Havering
LONDON BOROUGH

London Borough of Havering (20025659) – Responses to Written Representations

Thank you for the opportunity to respond to Written Representations made at Deadline 2. LB Havering would like to offer the following comments.

Drawing Title: **PETERSFIELD AVENUE
CONSTRUCTION TRAFFIC U-TURN
SWEPT PATH ANALYSIS
ARTICULATED VEHICLE**

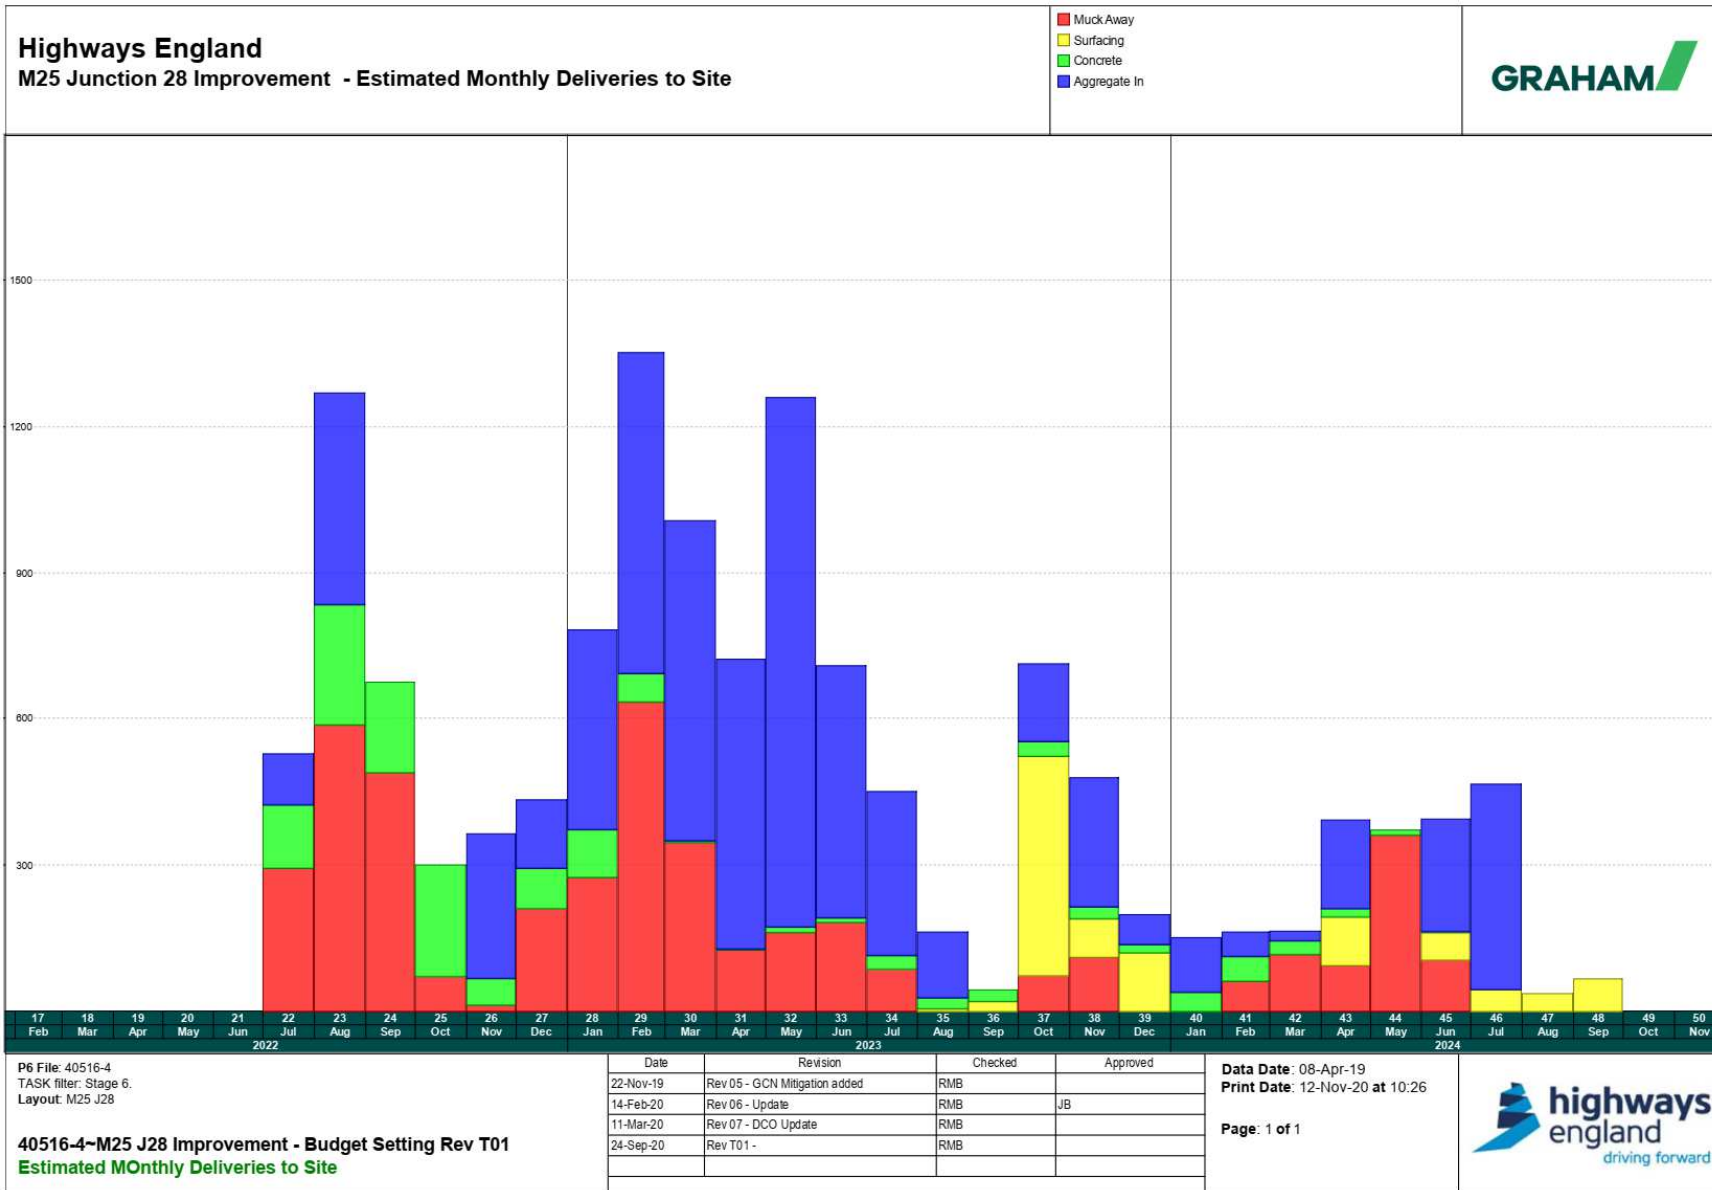
LB Havering shares the concerns set out by TfL in paragraph 7.6 with regards to the ability of large construction vehicles being able to "u-turn" at the A12 junction with Petersfield Avenue to travel eastbound along the A12 towards the construction site. LB Havering raised similar concerns in its response to the Transport Assessment Supplementary Information Report (TASIR) submitted at Deadline One (REP1-033) and again requests that the Applicant provide tracking data to provide the necessary assurances to stakeholders.
